CITY OF ALBUQUERQUE

PLANNING DEPARTMENT – Development Review Services

October 9, 2014

**RE: North Valley Clinic
Grading & Drainage Plan
Engineer's Stamp Date 10-1-2014 (File: G14D086)**

GRADING and DRAINAGE PLAN

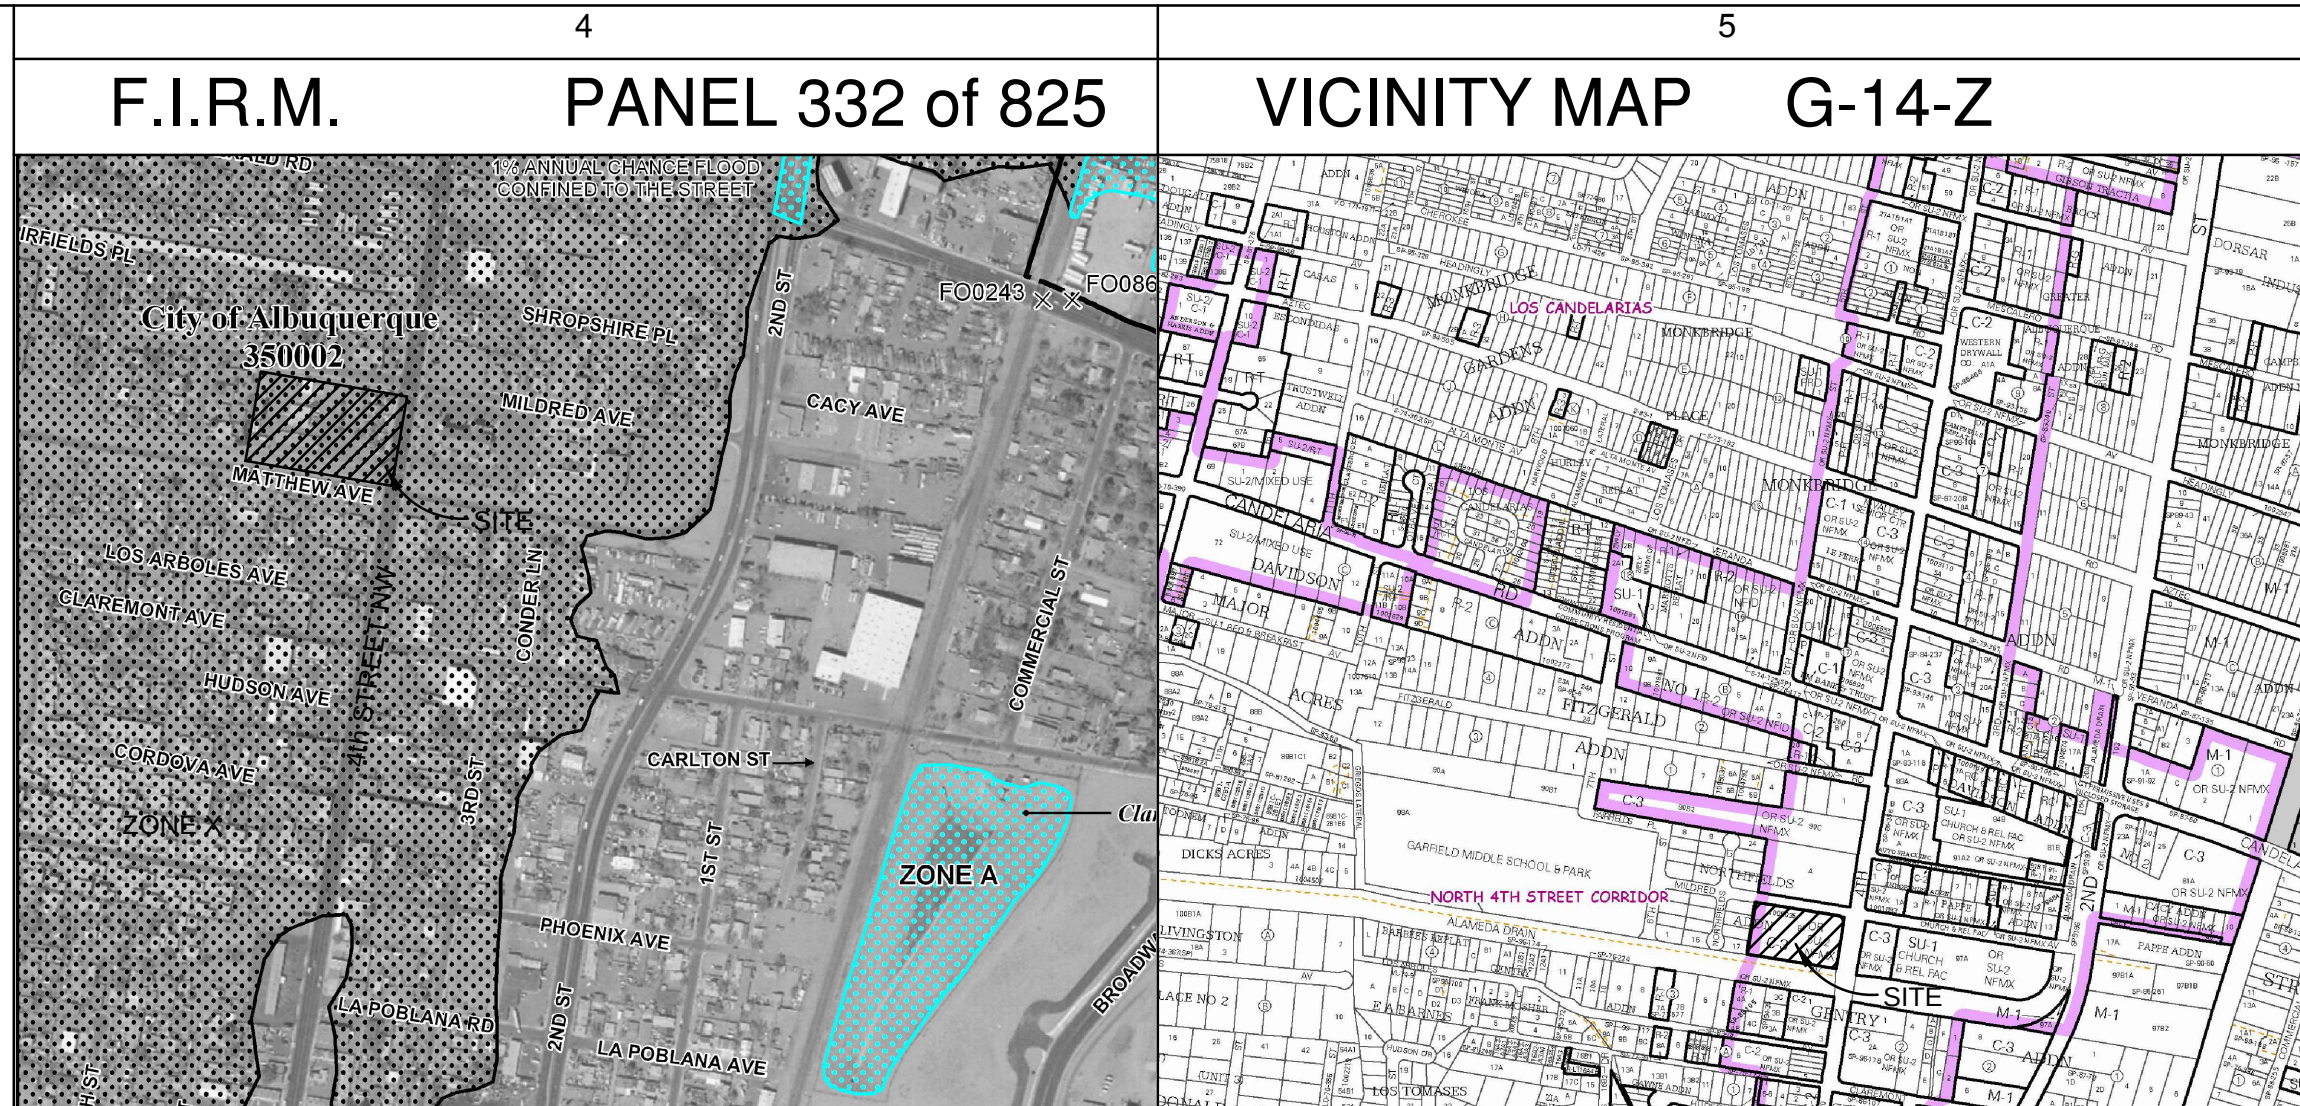
1. Since the private storm drain is to tie into a public inlet, an SO-19 Permit is required and a block for SO-19 notes with the signature block must be shown on the first sheet. I can provide you a copy of the notes if need be.

2. It seems that the parking lot in the SW corner of the property does not have the same outfall as the other areas of Basin III, and should therefore be in its own separate basin. It appears to discharge to parking islands and a landscape strip thru the center of the site, ultimately discharging to the NW corner of the site. Provide calculations showing that the volume contained in these areas is sufficient to limit the discharge to 2.75 cfs/acre at the NW corner of the site.

3. Provide a keyed note to the curb along the west property boundary.
4. Provide a detail showing how the private storm drain discharges into the landscaped area on the north side of the site.

5. Since the same landscaped area acts as a detention pond to capture the first flush, provide calculations showing there is enough volume to capture the first flush. The TG elevation of the catch basin (to the west of the drivepad) should be high enough to develop the first flush volume.

6. Referring to the previous comment: If the intent is to allow it to surge, it seems that it would also surge at the next inline catch basin which does not appear to be located in a ponding area. Does a detention ponding area need to be created here? If so, provide volume calculations. If the intent is to surge, take the head into account when calculating the flow thru the 10" SD and provide calculations.

7. Provide a keyed note to the above mentioned catch basins at the north side of site.
8. Remove keyed note 15 pointing to the west side of the curb return along the north property line.

9. Private SD goes from 6" to 10", a typo I presume.
